Subject: FW: Decision Notice DOC Individual Actual PLDNDOCIACT [14 Coastal Road]

Thank you for the Decision Notice for K/2/20/DOC, which confirms acceptance of Condition 7 [materials and finishes]. The Condition submission also covered Condition 4 [balcony glazing details]. Can you confirm that this is also covered by the Decision Notice?

REV.	DATE	DESCRIPTION
PROJECT		
14 COASTAL ROAD EAST PRESTON BN16 1SJ		
DRAWING		
PROPOSED EAST & SOUTH ELEVATIONS		
CLIENT		
MRS & MR CLARKE		
SCALE	DRAWN	
1:50 @ A1 / 1:100 @A3		
DATE	CHECK	
FEBRUARY 2020		
DRAWING No.	REVISION	
1714- PL1-09	D	
© copyright retained

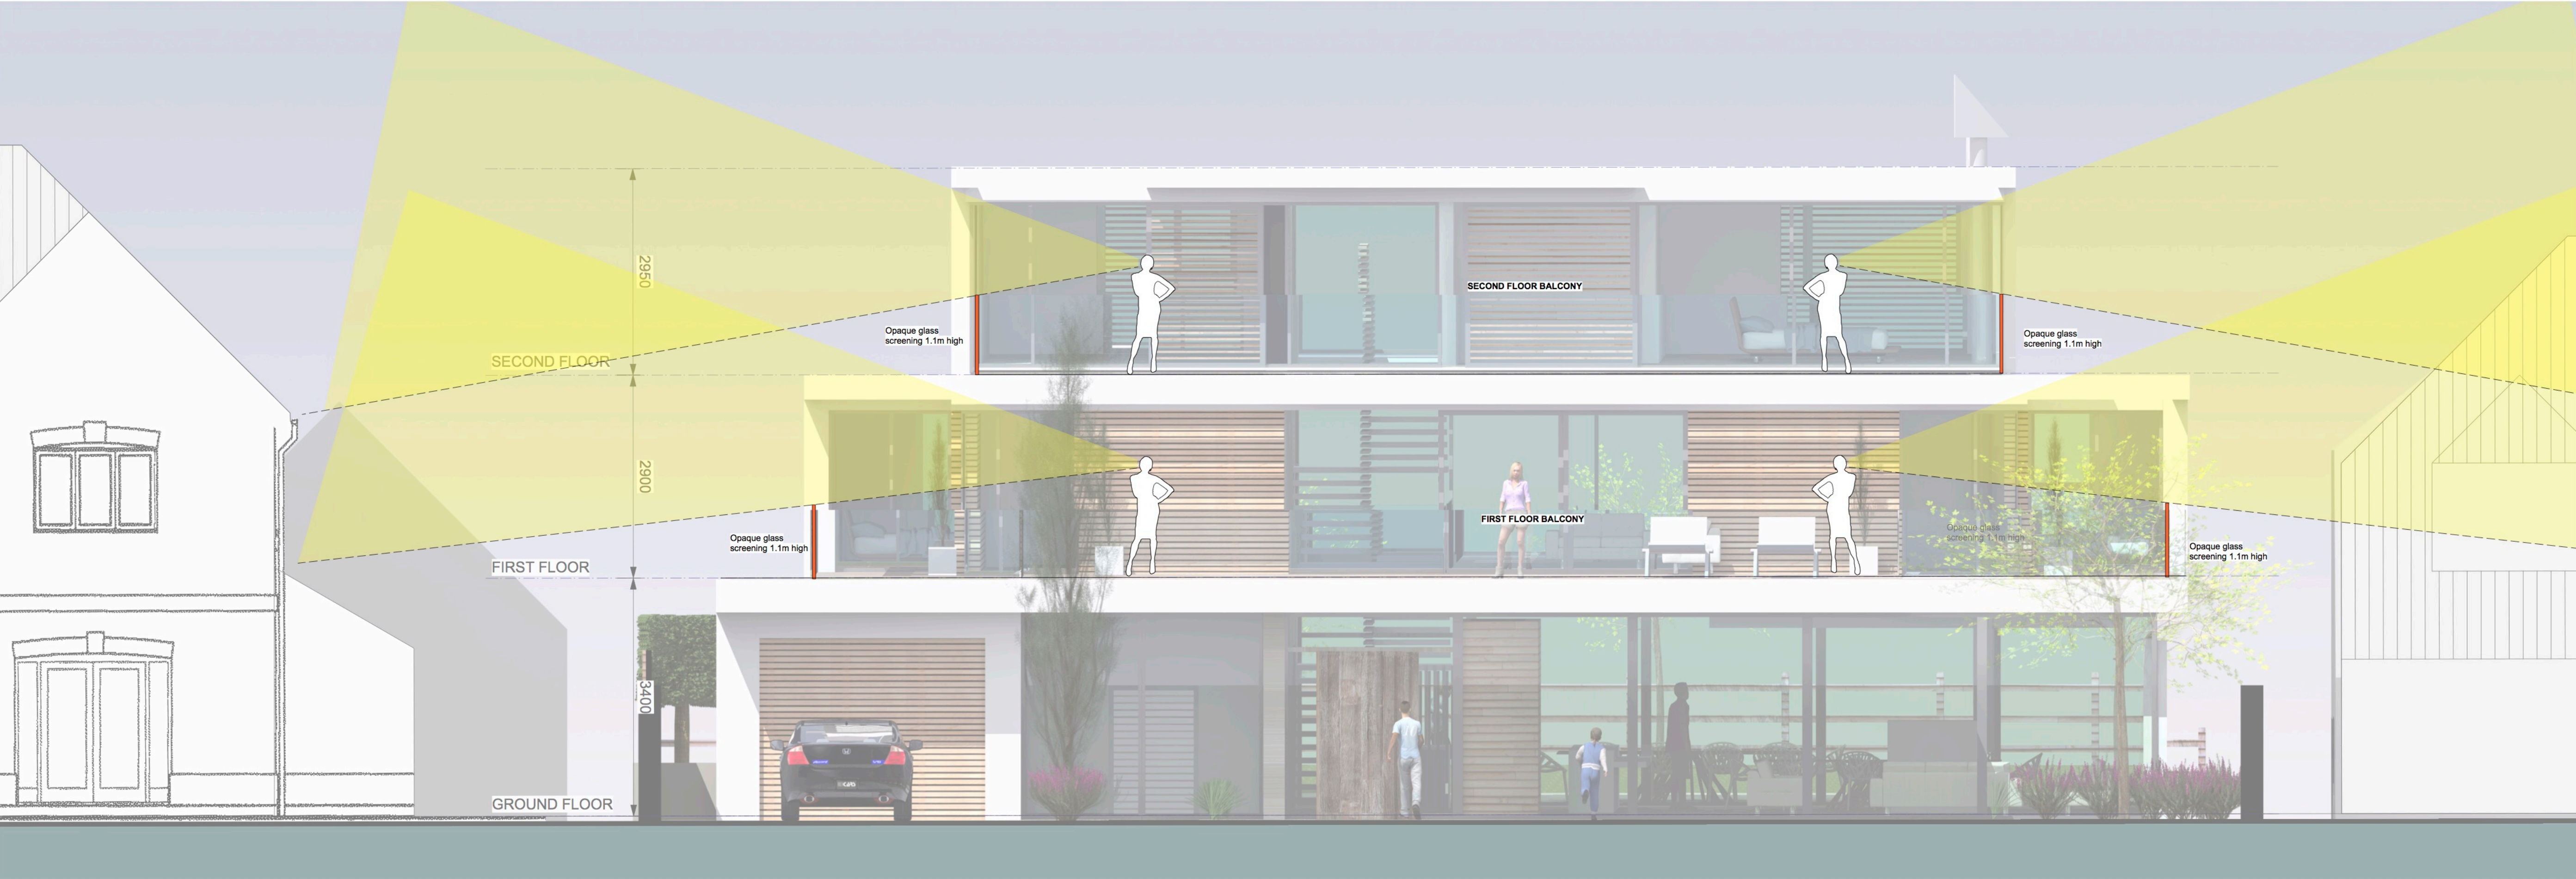
When you speak to your Team Leader, please could you advise him that my client has been advised that higher balconies are not advised because of the high winds experienced here. The approved plans also show the balcony screens to 1.1m high. This is considered acceptable because the balconies are placed to the frontage of the building and over look open, front gardens with low dwarf walls at their front boundary, rather than private, rear spaces where, ordinarily higher levels of privacy are experienced. The only rear balcony is also adjacent to an area used for car parking.

The other condition is not covered by the decision notice a separate letter will be issued shortly, but I need to discuss the submitted information with my Team Leader first. I am not sure that the sides are sufficiently high.
